Application by Morecambe Offshore Wind Limited for Morecambe Offshore Windfarm Generation Assets

The Examining Authority's written questions and requests for information (ExQ1)

Representations on behalf of BAE Systems (BAE Systems Marine Limited – Walney and BAE Systems (Operations) Limited – Warton)

Figure 2: MSA NDB(L) BPL Obstacle Protection Area

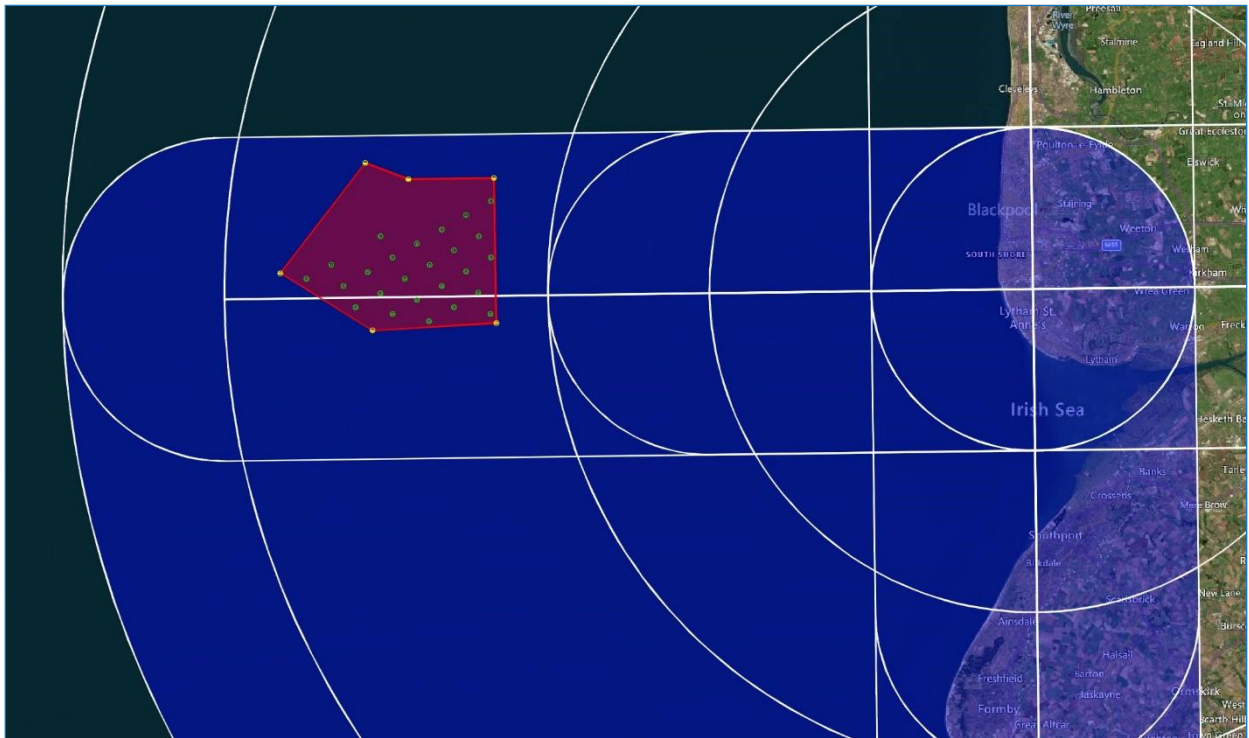
1CAR12	The Applicant BAE Systems Marine Ltd NATS	<p><b>Walney Aerodrome – Minimum Sector Altitude (MSA)</b> Paragraph 2.10.3.2 of Appendix 16.2 [APP-078] indicates that the published MSA for Walney Aerodrome would need to be increased to maintain the necessary 300m obstacle clearance protection. In its RR BAE Systems Marine Ltd [RR-007] has indicated that the gap must be 305m and that BAE needs the height of the wind turbines to be verified by NATS. The Applicant’s response ([PD1-011], RR-007-005) states that NATS has been commissioned to carry out an Instrument Flight Procedure (IFP) assessment on behalf of BAE and Walney Aerodrome and the results of this are expected in late 2024.</p> <p><u>To BAE Systems Marine Ltd:</u></p> <p>a) Please clarify and confirm what the published MSA for Walney Aerodrome is and provide evidence to support this – i.e. is this 300m or 305m?</p> <p><u>To the Applicant and NATS:</u> Please provide a copy of the NATS IFP assessment and its findings or, if this is not yet available, an update and likely timeframe for when this will be completed?</p>	<p><b><u>BAE Systems Marine Limited, Walney</u></b></p> <p>The Cyrrus report which was conducted for the Applicant incorrectly stated 300m as the required separation.</p> <p>The minimum figure required by CAA Regulation is 1000ft (305m).</p> <p>AIP shows the sector safe height is currently 1800ft (aviation height is measured in feet not metres). <a href="https://nats-uk.ead-it.com/cms-nats/opencms/en/Publications/AIP/Current-AIRAC/graphics/368877.pdf">https://nats-uk.ead-it.com/cms-nats/opencms/en/Publications/AIP/Current-AIRAC/graphics/368877.pdf</a></p> <p>For the required 1,100ft tip height a sector safe altitude of 2,100ft would be required with associated change to approaches and MSA.</p>
